| <b>Consultation Response from KC,<br/>Trees</b>                                                                                                                                                                                                |
| <b>2025/93543 land at, former Clough Mill, Clough Road, Slaithwaite, Huddersfield, HD7 5DB</b>                                                                                                                                                 |
| <b>REVISED AND ADDITIONAL INFORMATION RECEIVED, AND REVISED DESCRIPTION: Erection of 31 dwellings (c3) with access from Clough Road and associated works including engineering operations, construction of retaining walls and landscaping</b> |
| <b>Date Responded: 30/09/2026<br/>Responding Officer: JD<br/>Responding Ref: 01/17</b>                                                                                                                                                         |

Proposed Layout
Design Review

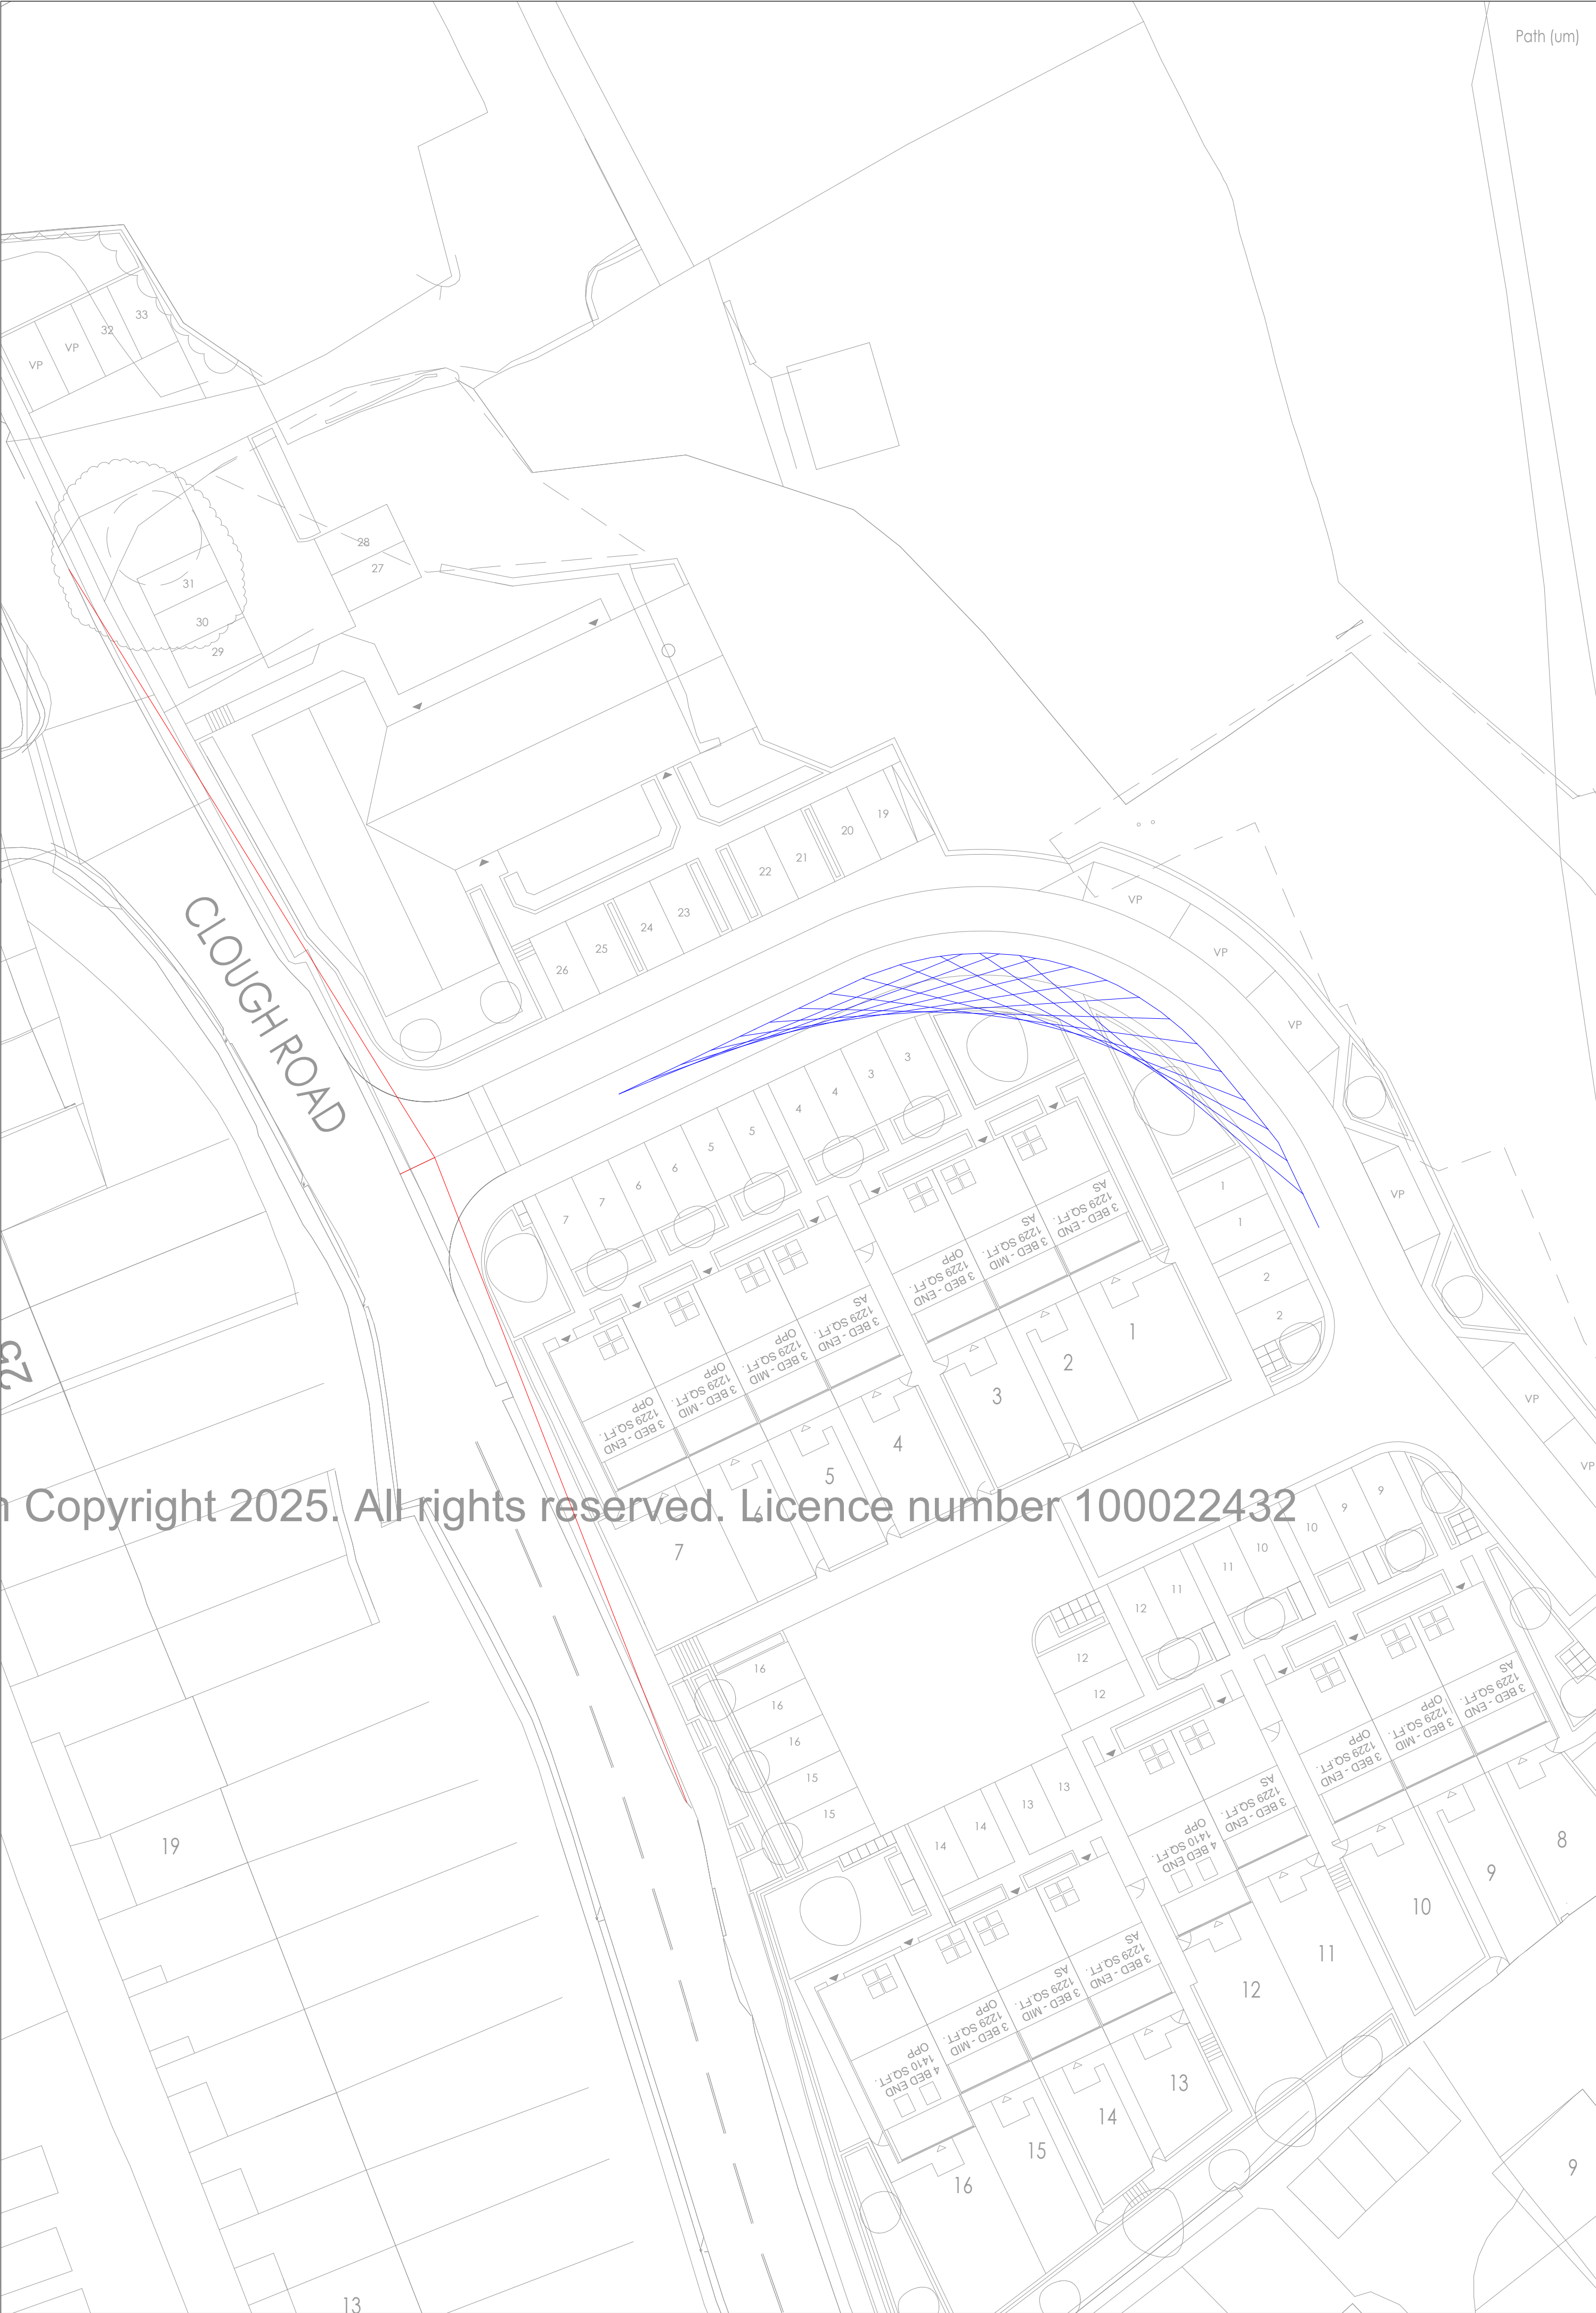
The only changes which affect the trees on site appear to be with regards to the parking bays under the canopy of T3. The revised plans suggest that the bay closest to the trees stem is to be removed with soft landscaping in its place. This is generally welcomed from KC trees as it provides T3 more space and avoids accidental collisions with the trees stem.

The area allocated as communal open space appears to not change the previously agreed tree removal and providing no level changes are proposed or earth works this would be acceptable as the canopies of retained trees will offer shade and amenity value to the site.
